## KITTITAS COUNTY COMMUNITY DEVELOPMENT SERVICES

June 19, 2018

RE: Mitchell Short Plat (SP-17-00003) - Request for Additional Information

NANEUM ROAD SHORT PLAT
PART OF SECTION 33, T. 18 N., R. 19 E., W.M.
KITITAS COUNTY, WASHINGTON

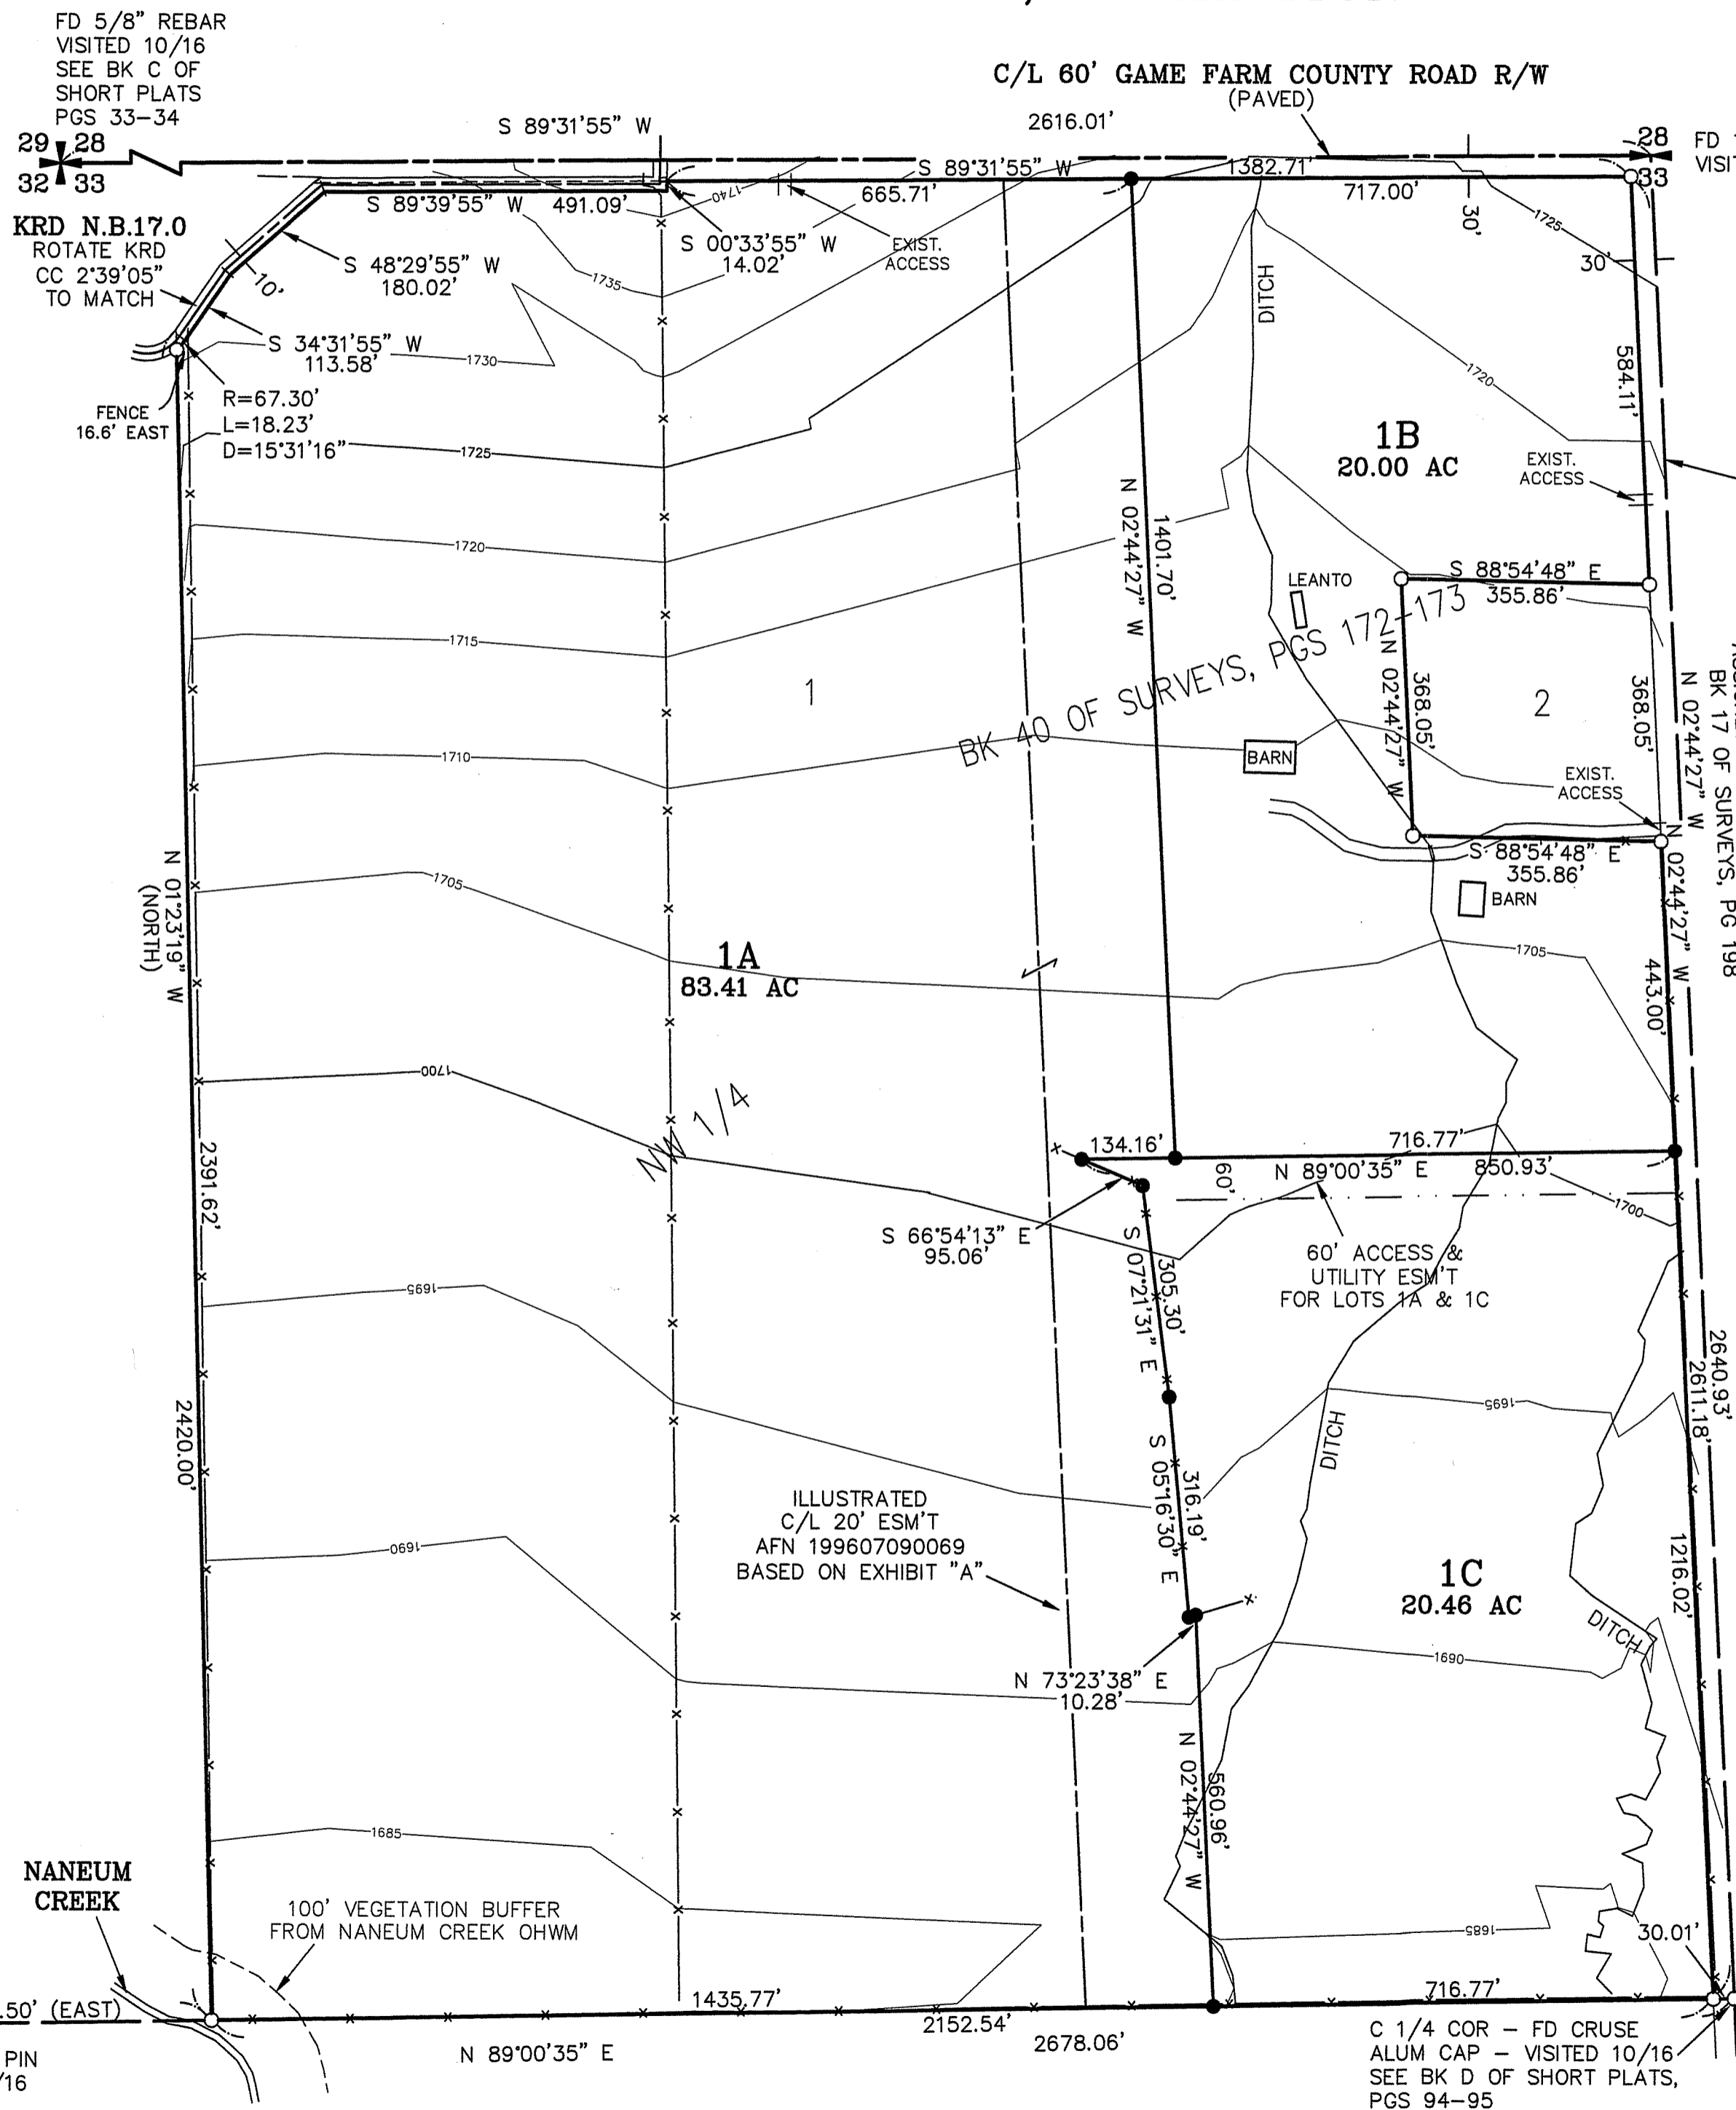
Staff has reviewed the submitted wetland study received by CDS on June 4, 2018. In order to proceed with processing of your short plat application, we will need a large scale very detailed site plan showing the proposed house location, well location and well protection radius, septic system, critical areas, specific location of access, and all setbacks from these elements. The site plan provided with the wetland study is too small of a scale to verify that all of these elements will fit in your proposed buildable area. Please contact me if you have any further questions.
